From: Paul Cann
Sent: 07 June 2017 16:33
To: Planning.Responses
Subject: RE: Planning Consultation on P/49/17/DOC

Comments in respect to surface water drainage scheme (condition no.4);

Site Address: Church Farm Holiday Village Church Lane Pagham PO21 4NR

Description of Works: Application for approval of matters reserved by conditions imposed under P/84/16/PL relating to conditions 3- Foul water drainage scheme, 4- Surface water drainage scheme, 5- Site safety plan, 7- Implementation of a programme of archaeological work, 8- Golf Course management plan, including mitigation & 9- Details of placement of nesting opportunities for birds.

DRAWING TITLE
CHURCH FARM GOLF DEVELOPMENT
SECTIONS AND DETAILS

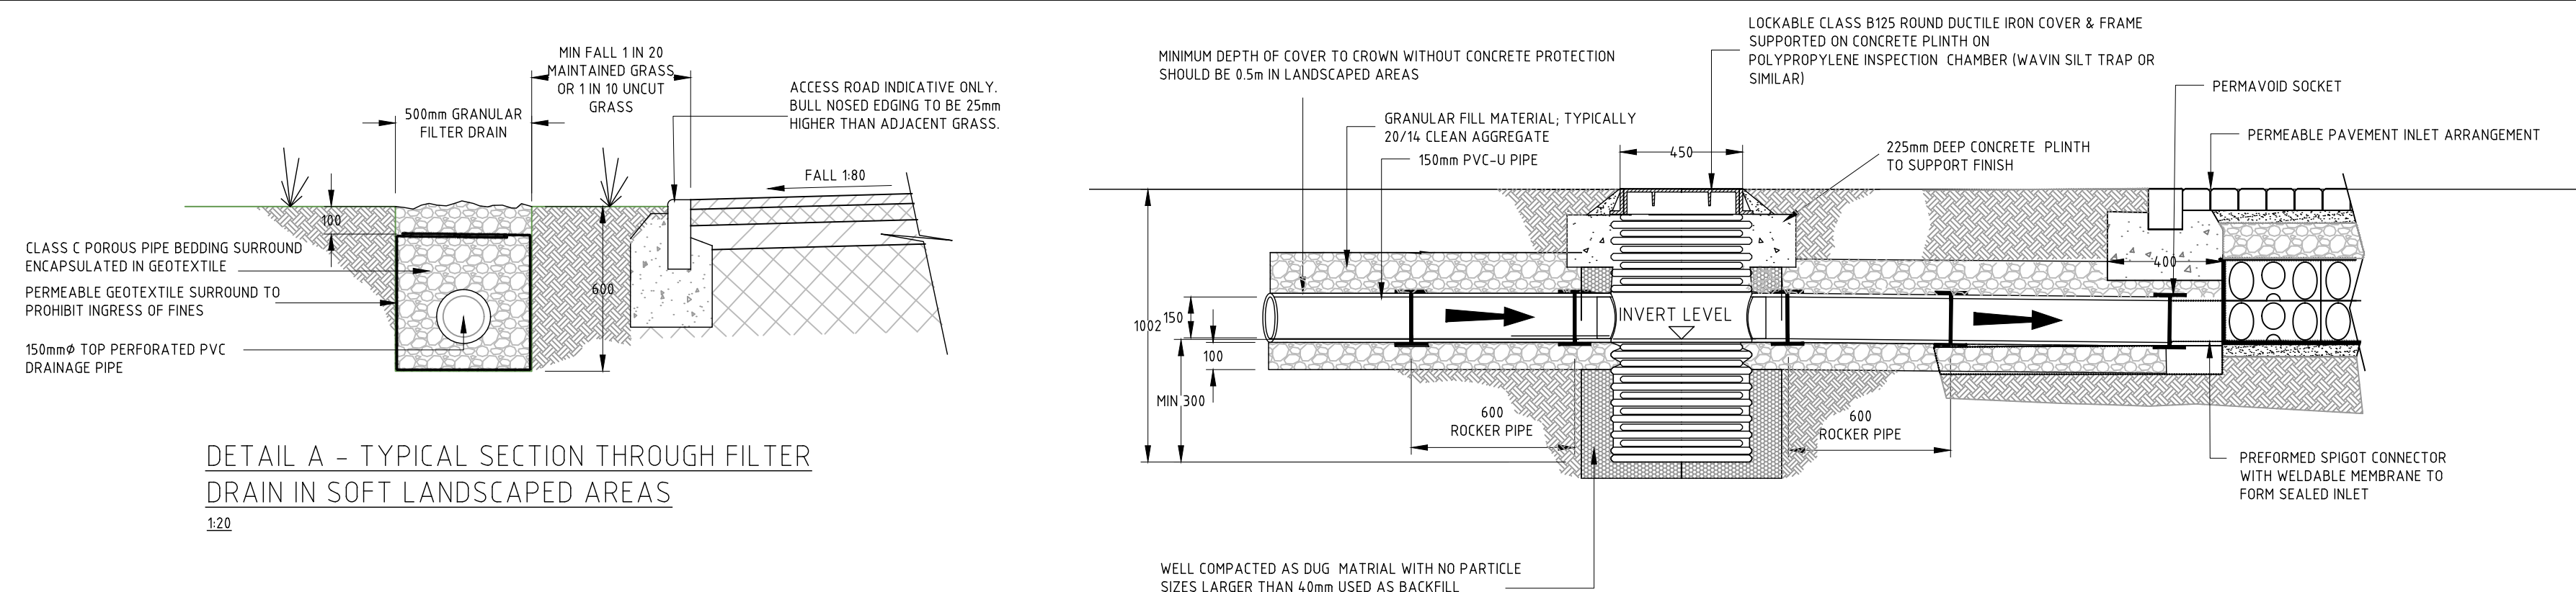
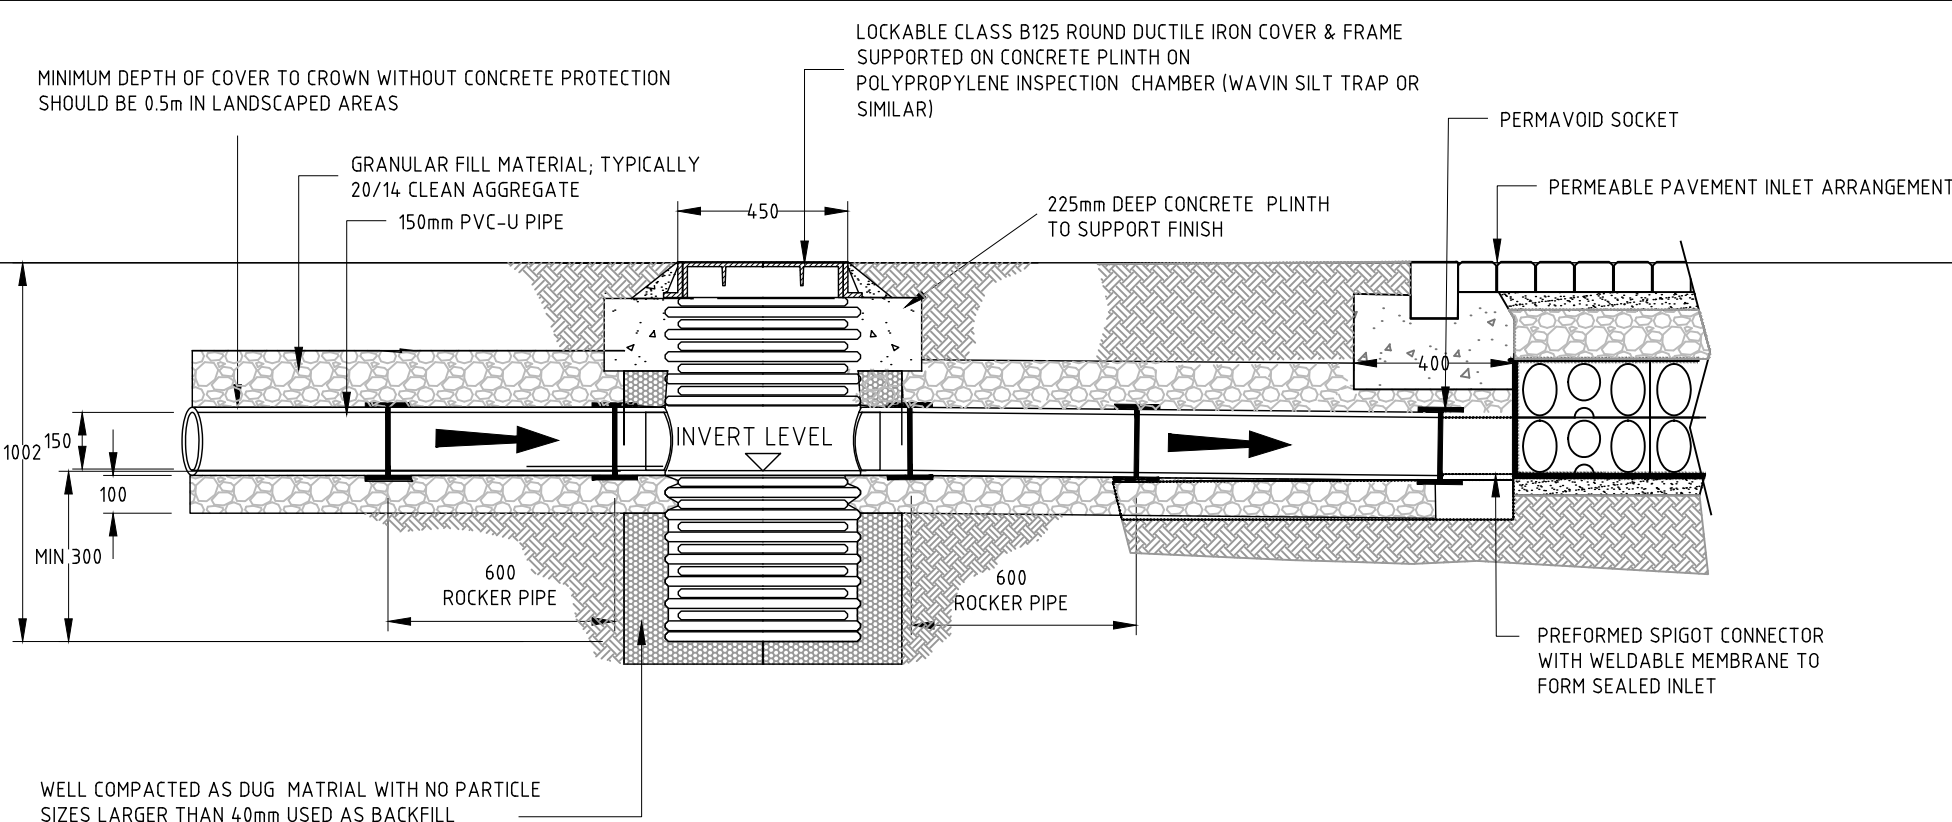
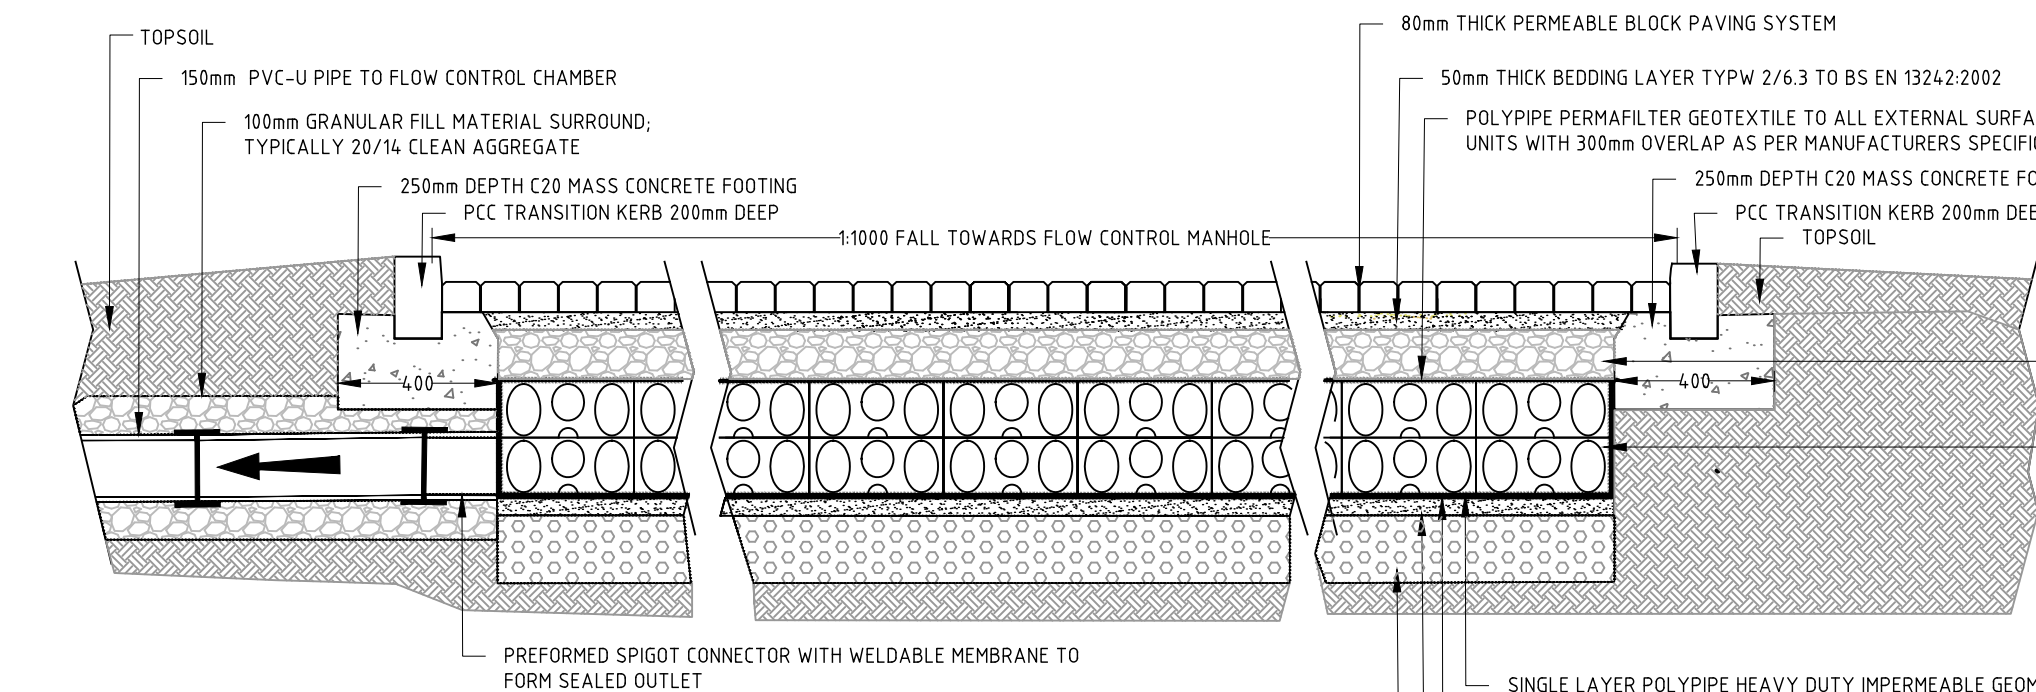
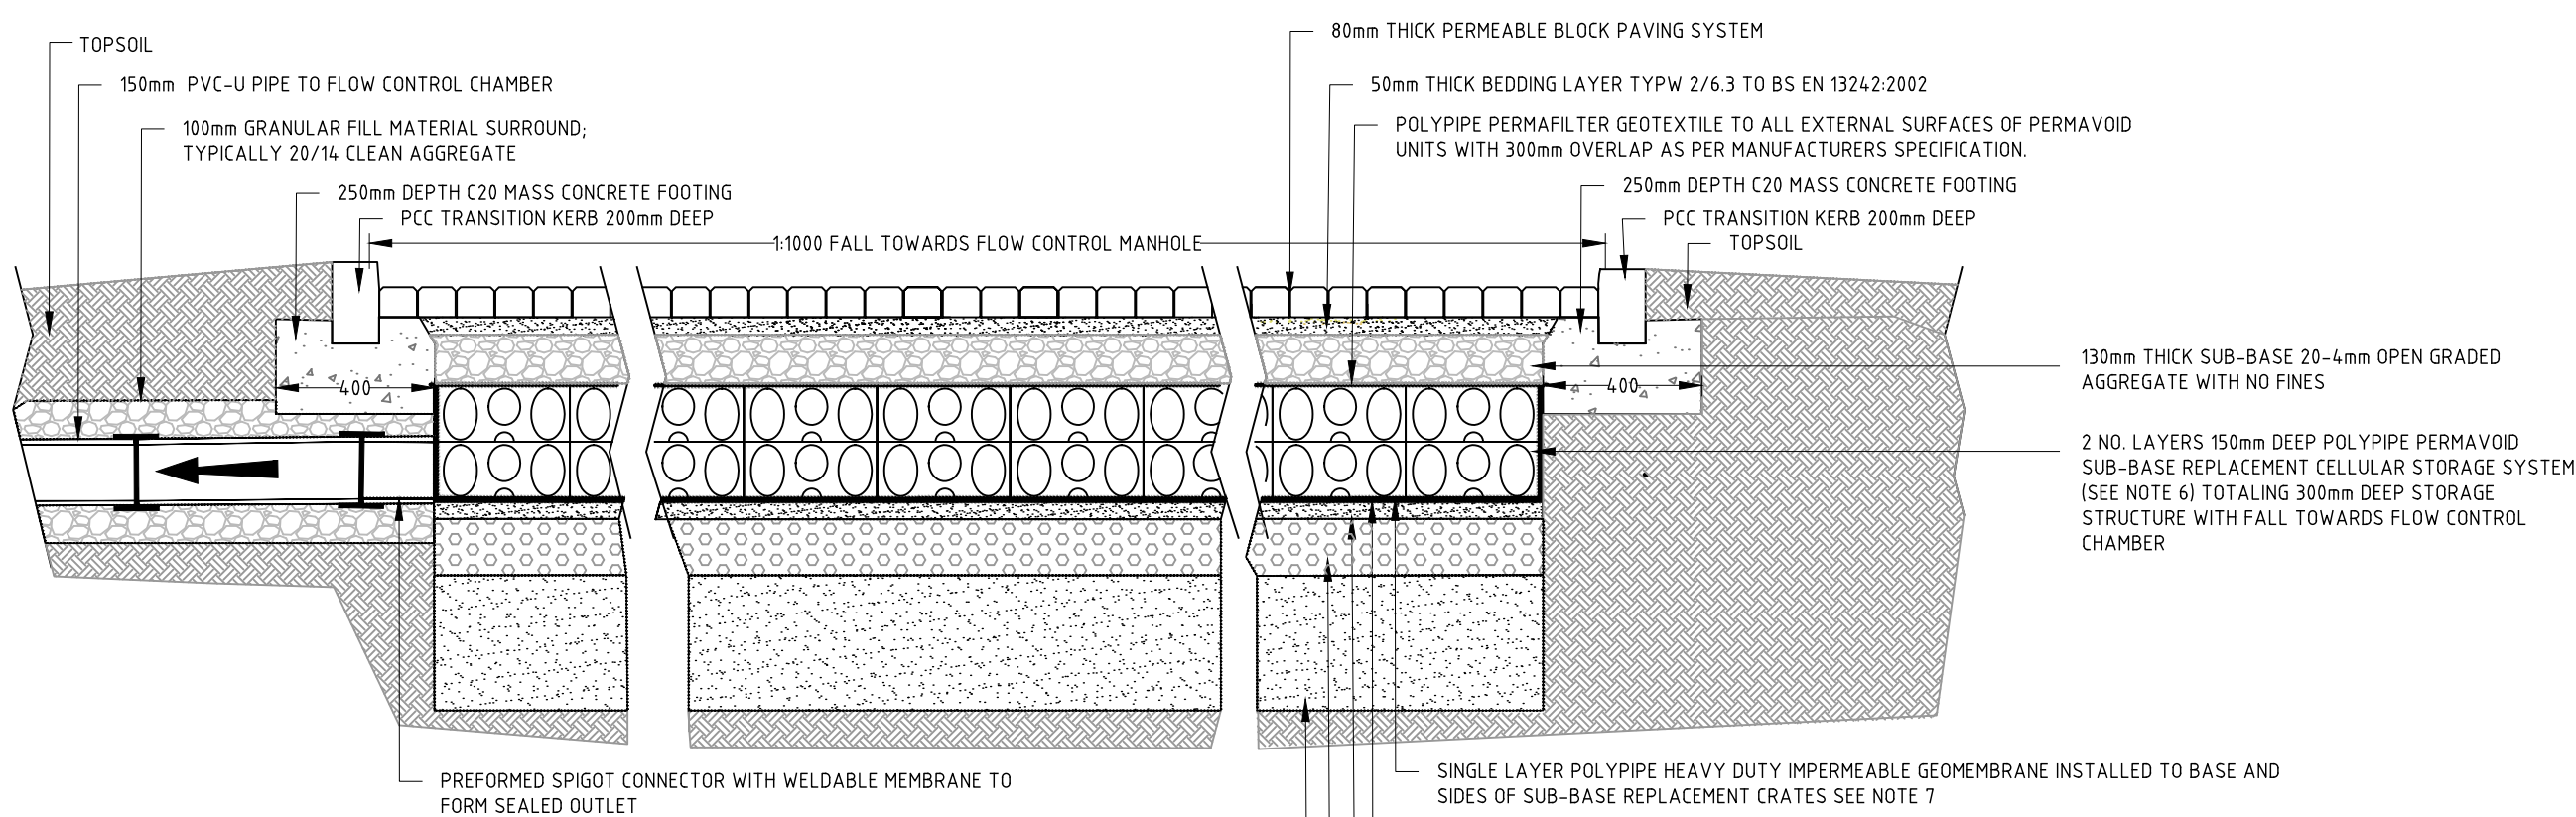
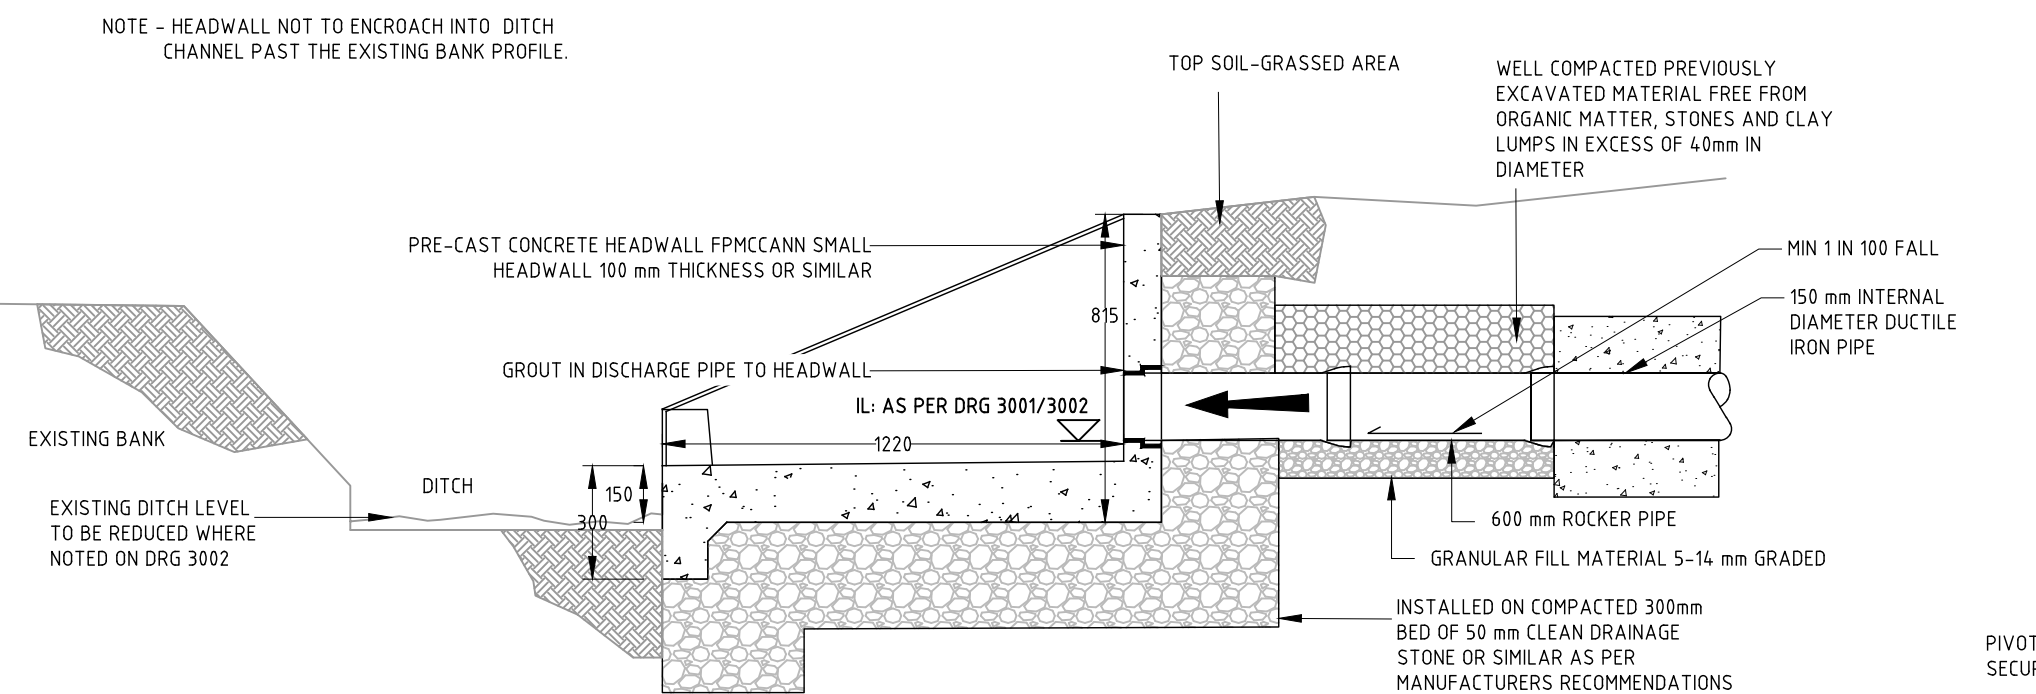
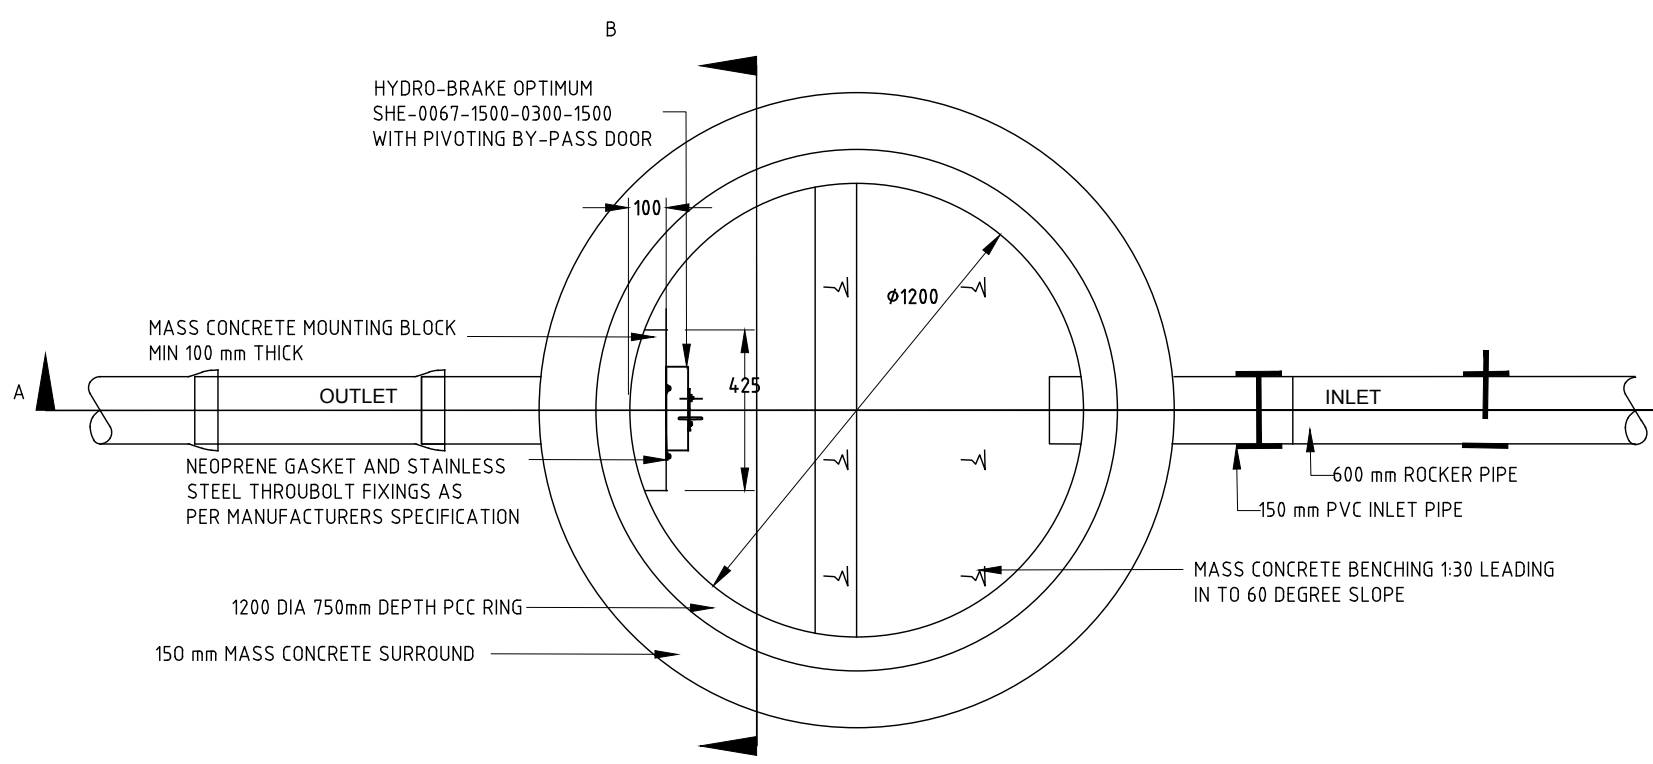
8. Provide construction detail drawings for the permeable pavements/flow control chambers/filter drain/filter drain manholes (silt traps)/headwalls/pipe inlet arrangement to permeable pavements/pipe bedding & pipe spec for outlet pipes/raised flood attenuation kerbing.
